DOC18/179866-02
SSD 8574

27 April 2018

SSD 8574 – WAITARA PUBLIC SCHOOL RE-DEVELOPMENT – ENVIRONMENTAL IMPACT STATEMENT (EIS)

- ENVIRONMENT PROTECTION AUTHORITY COMMENTS –
SSD 8574 WAITARA PUBLIC SCHOOL RE-DEVELOPMENT EIS

Client Project	NSW DEPARTMENT OF EDUCATION WAITARA PUBLIC SCHOOL REDEVELOPMENT		
Title	CIVIL EARTHWORKS PLAN		
Original Size	A1	Drawing No:	21-26108-WA-SD-CI-1030
Rev:	E

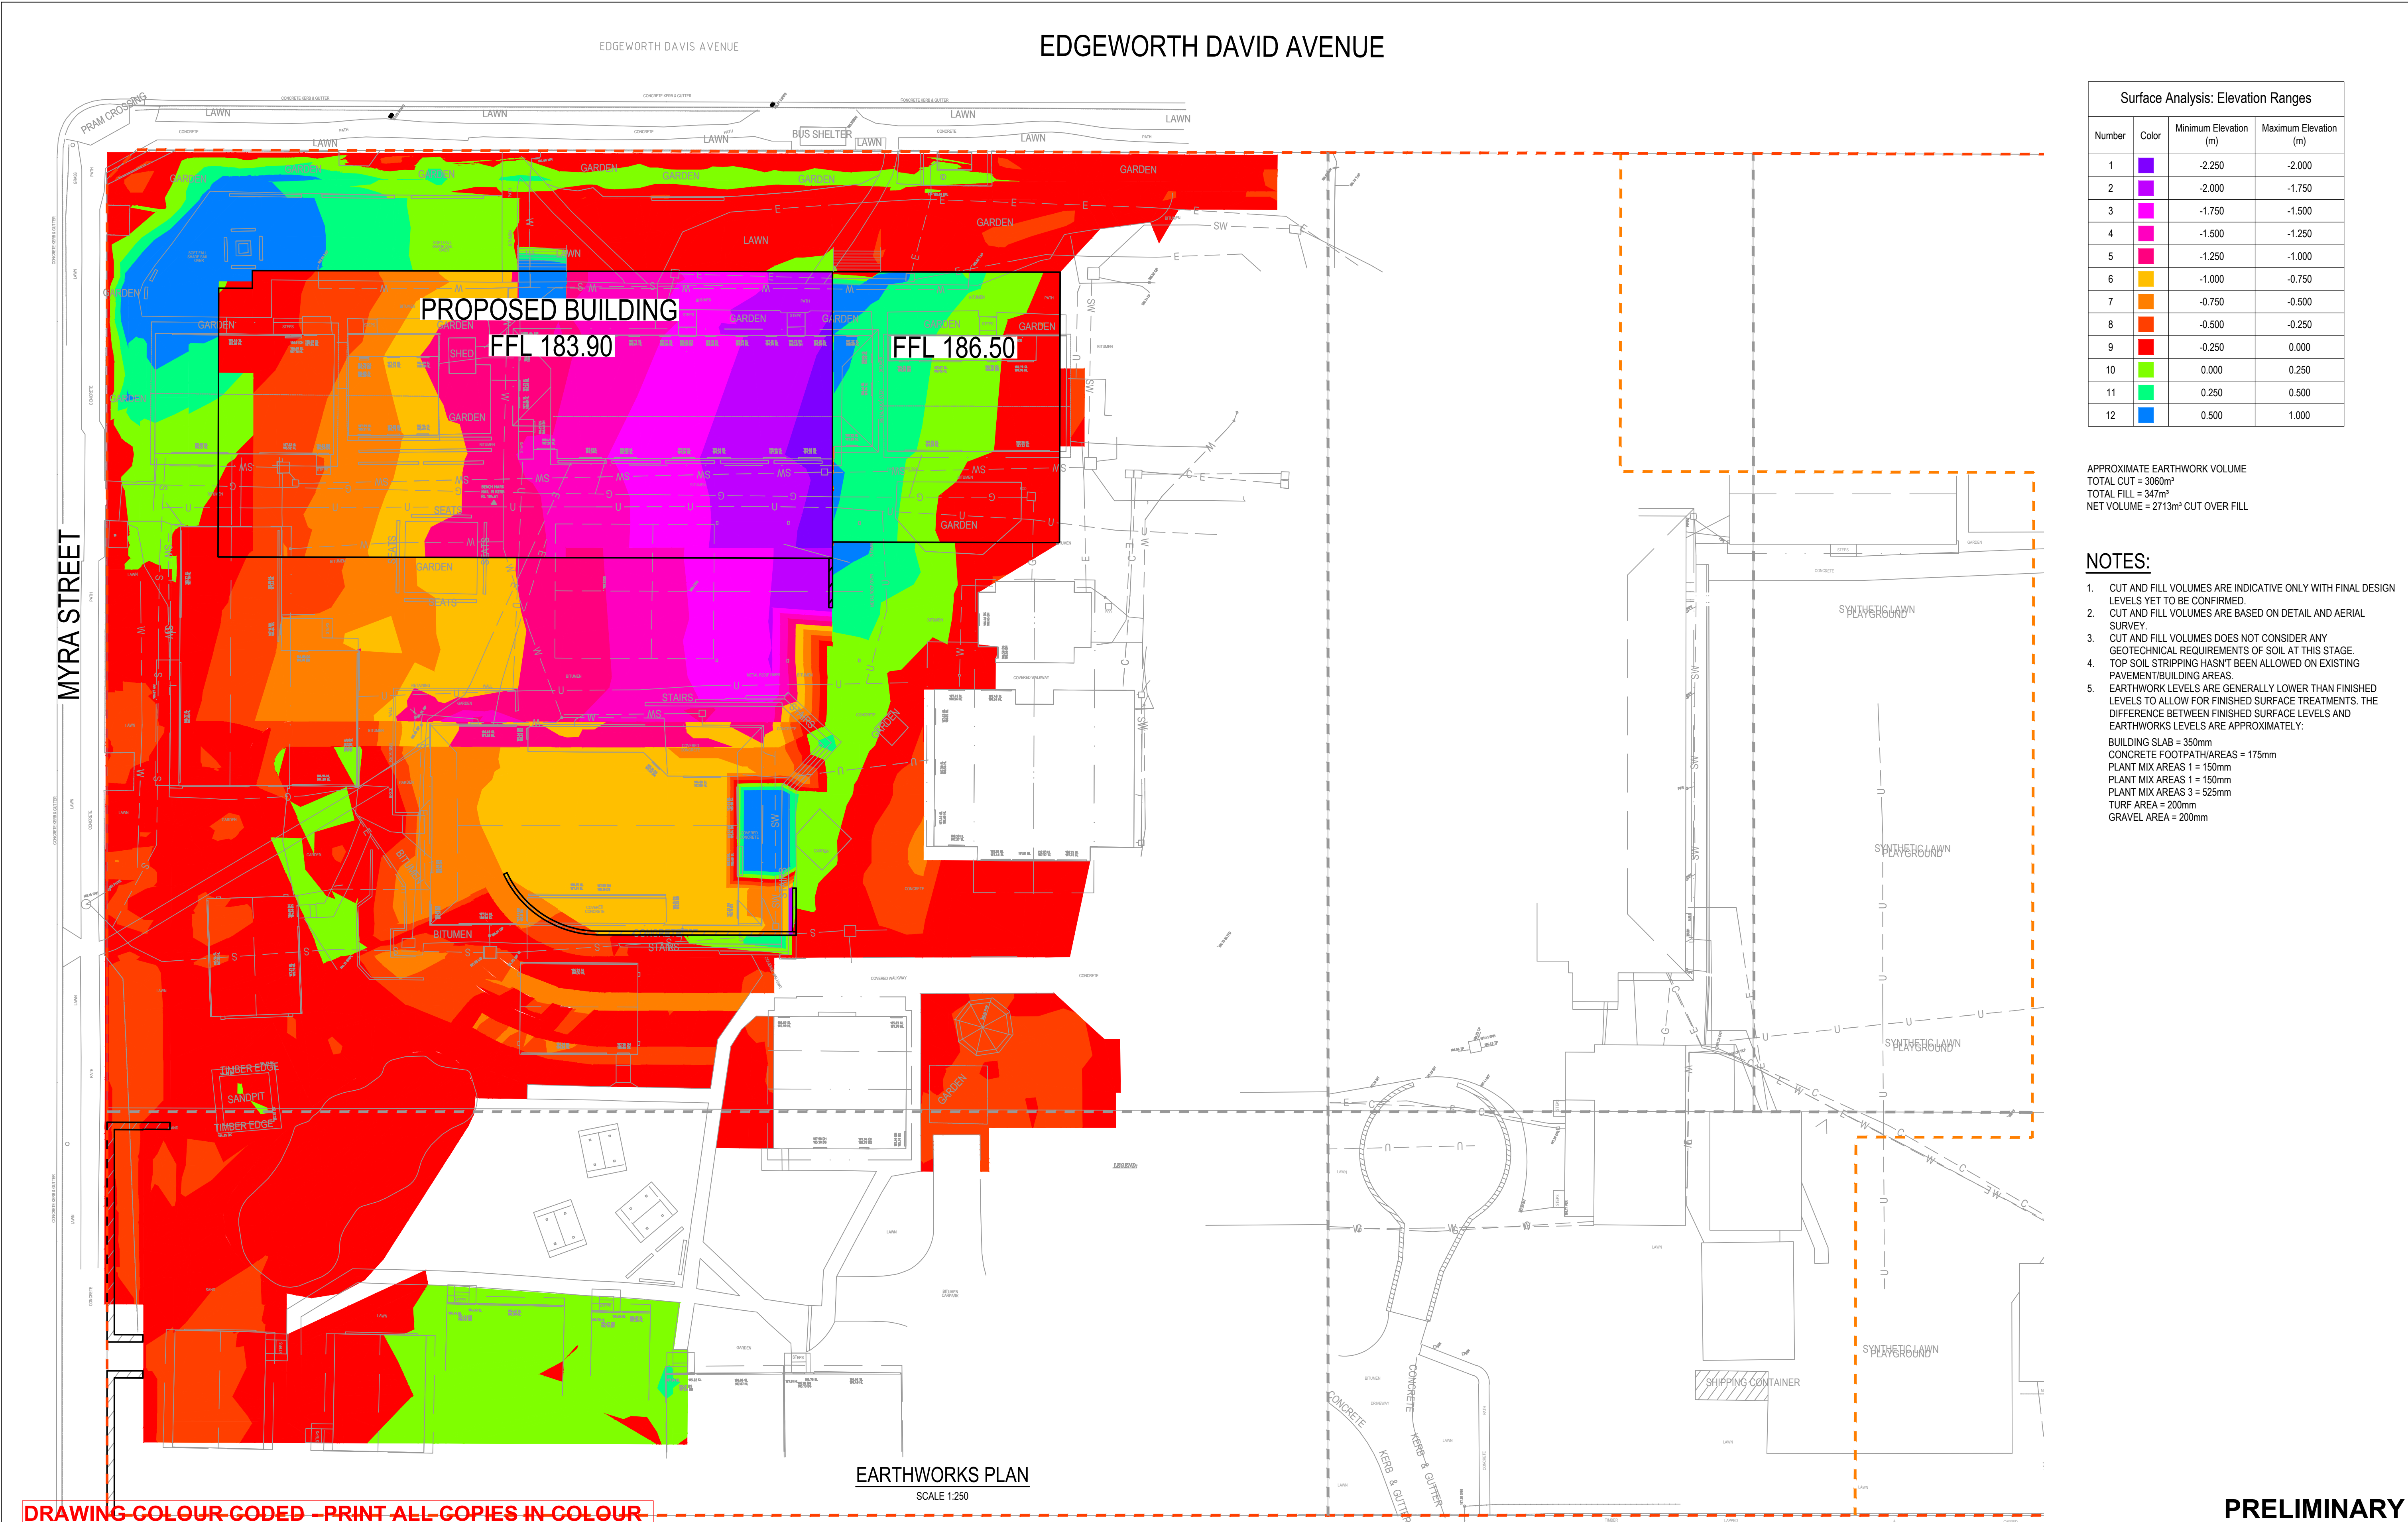
The EPA's Sampling Design Guidelines recommend the number of sampling points for the lot area of the proposed school re-development (18,256 m²) to be between 25 to 30 sampling points. However, the ESA report indicates that –

- (a) soil sampling was only undertaken at 8 boreholes,
- (b) stratified soil sampling was not undertaken,
- (c) most of the development site is sealed and that there were no odours, surface soil sampling, soil discolouration or asbestos containing materials (ACM) that were observed on accessible ground surfaces at the time of inspection,
- (d) depth to groundwater is likely to be greater than 10 metres below ground surface and given the low concentrations of analytes in soil and the anticipated depth, groundwater need not be investigated, and
- (e) "... given the limited extent of investigations, implementation of an appropriate unexpected finds protocol implemented during development works would enable management of any unidentified contamination".

The proponent be required to ensure that following relocation or demolition of any existing structures and in ground utilities further investigation be undertaken of soil contamination within the footprint of those structures and utilities prior to undertaking any construction.

- (a) implement the processes outlined in *State Environmental Planning Policy 55 - Remediation of Land (SEPP55)*, to assess the suitability of the land and any remediation required in relation to the proposed use;
- (b) undertake soil sampling in accordance with the EPA's Sampling Design Guidelines and conduct a detailed site investigation and prepare a remedial action plan to address any contamination subsequently found;
- (d) have regard to the following guidance when assessing contamination at the site:
 - (i) EPA Sampling Design Guidelines
 - (ii) Guidelines for the NSW Site Auditor Scheme (3rd edition) 2017

Client	NSW DEPARTMENT OF EDUCATION		
Project	WAITARA PUBLIC SCHOOL REDEVELOPMENT		
Title	CIVIL EROSION AND SEDIMENT CONTROL PLAN		
Original Size	A1	Drawing No:	21-26108-WA-SD-CI-1035
Rev:	E

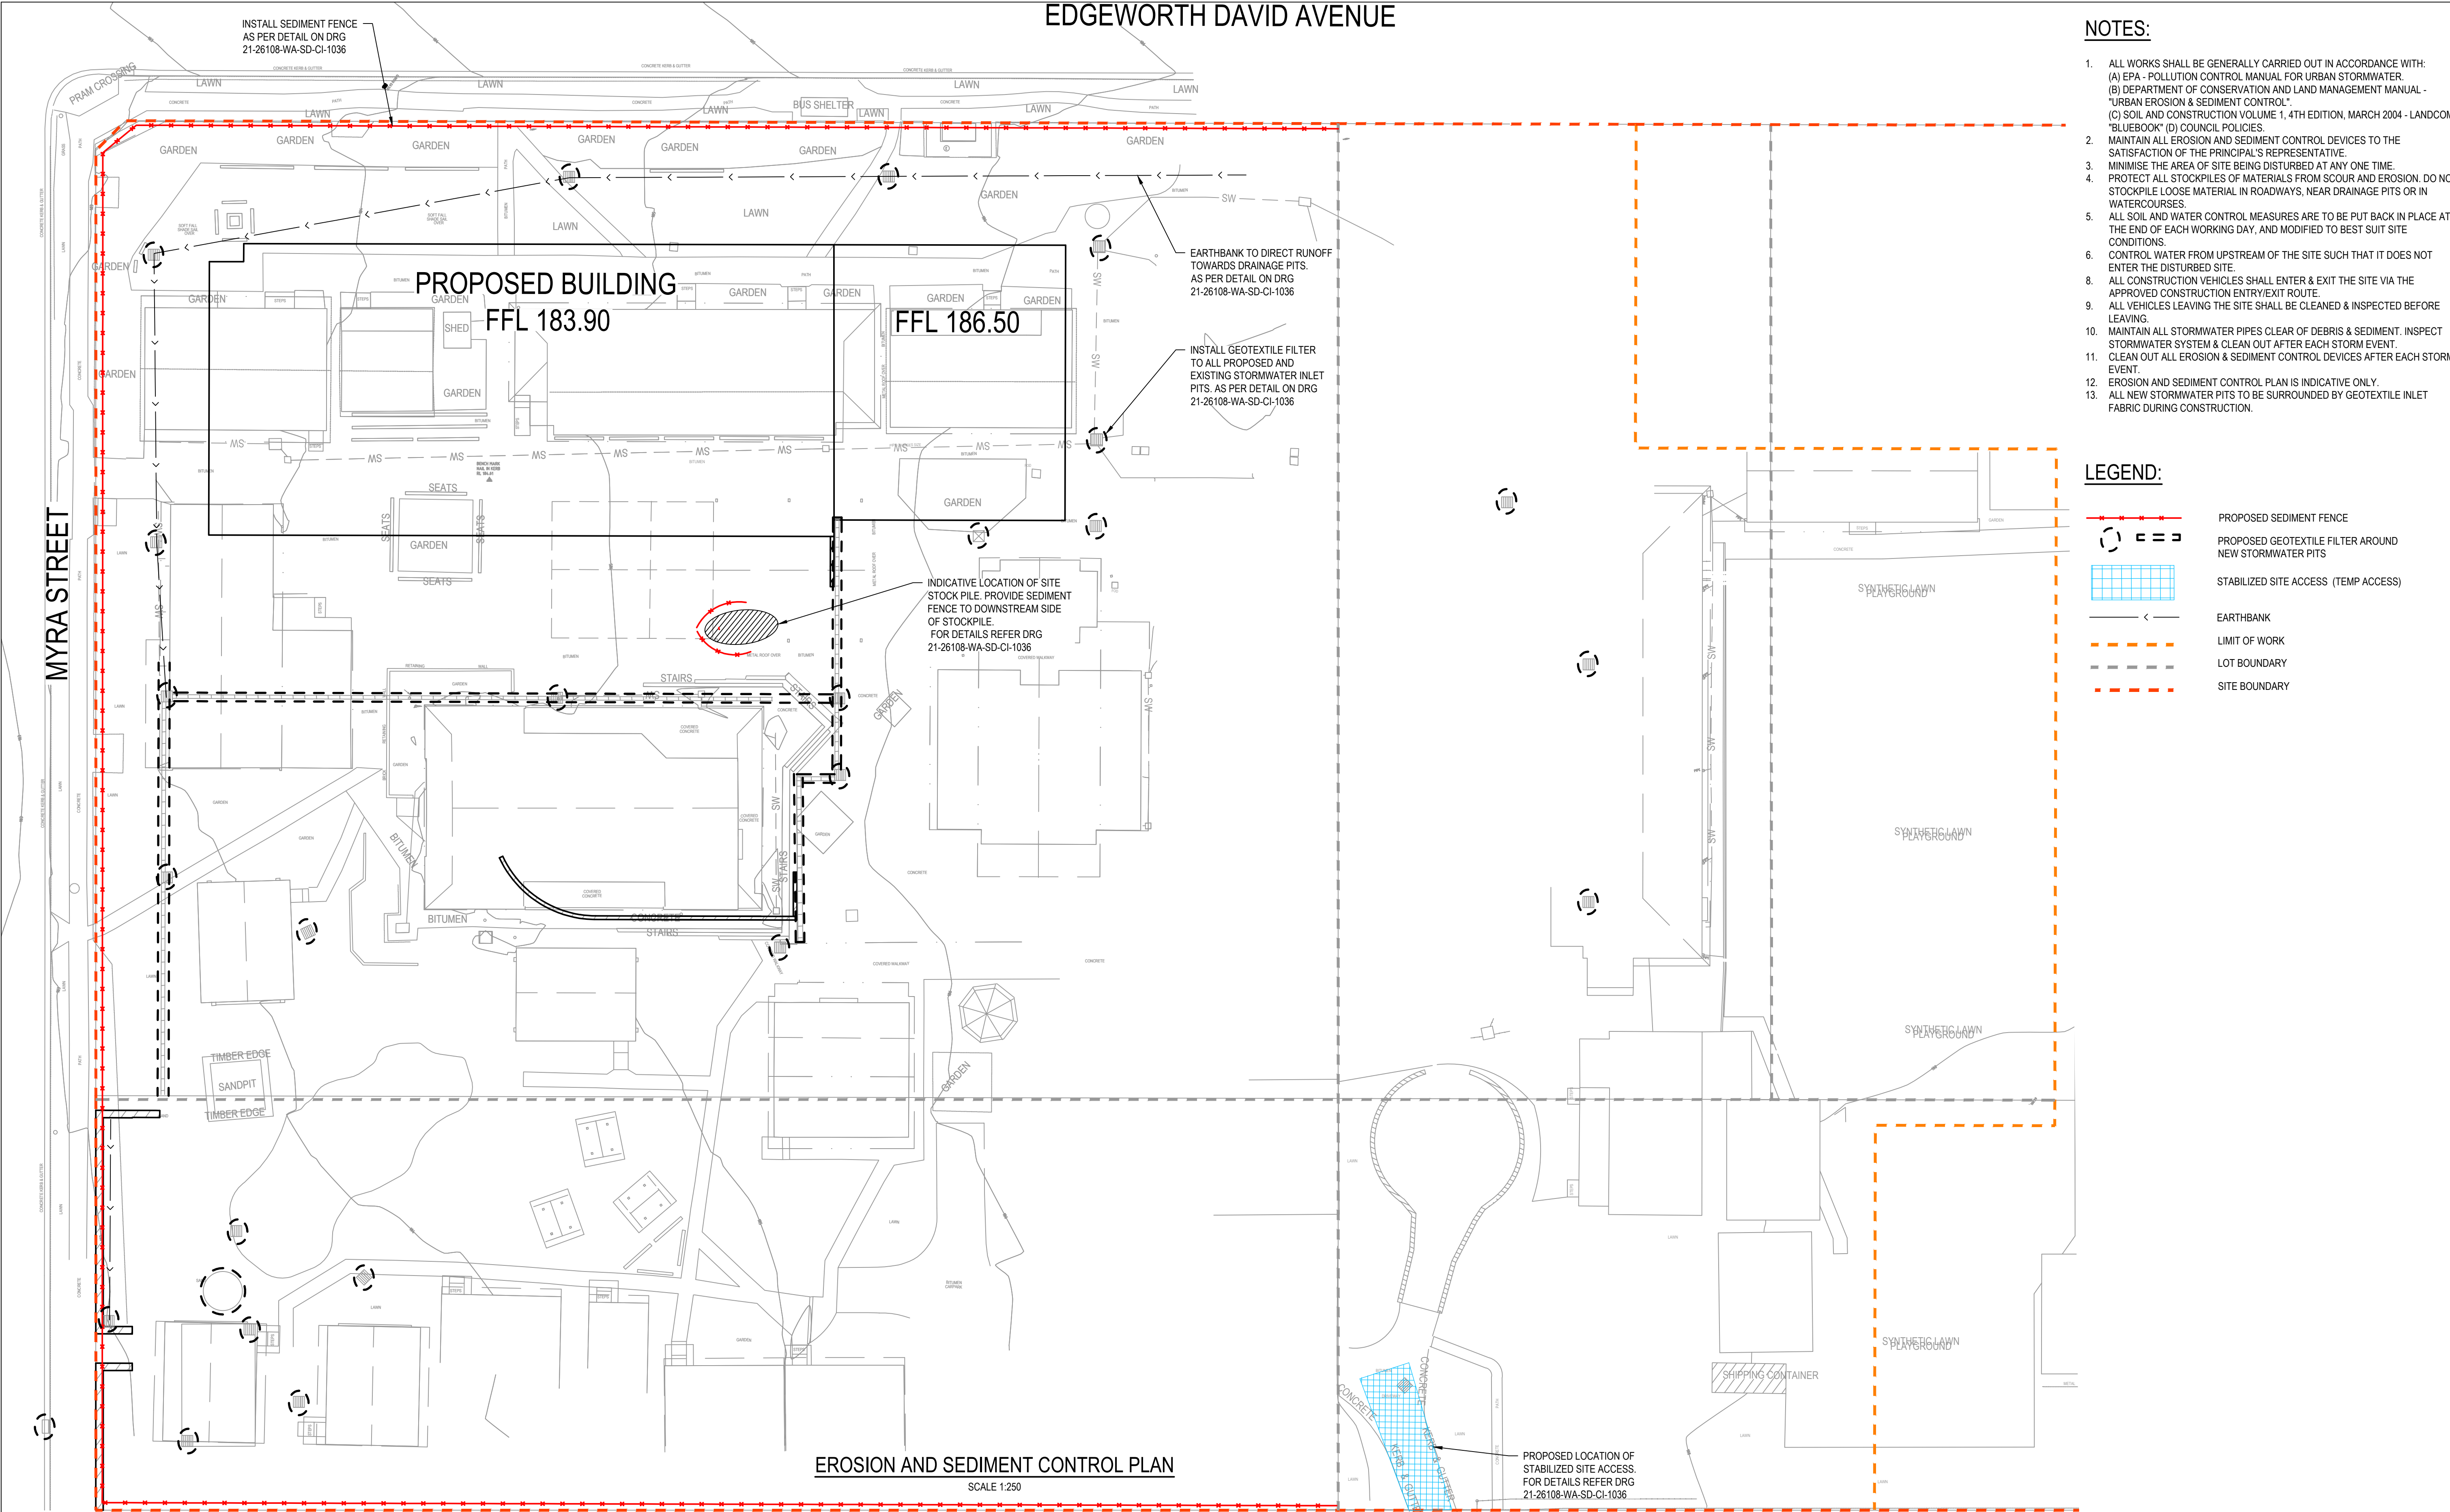
Managing Urban Stormwater Soils and Construction, 4th Edition published by Landcom (the so-called 'Blue Book') provides guidance material for achieving effective sediment control on construction sites. The proponent should implement all such feasible and reasonable measures as may be necessary to prevent water pollution in the course of developing the site.

- (a) not commencing demolition, site preparation, bulk earthworks, construction and construction-related activities until appropriate and effective sediment controls are in place, and
- (b) daily inspection of sediment controls which is fundamental to ensuring timely maintenance and repair of those controls.
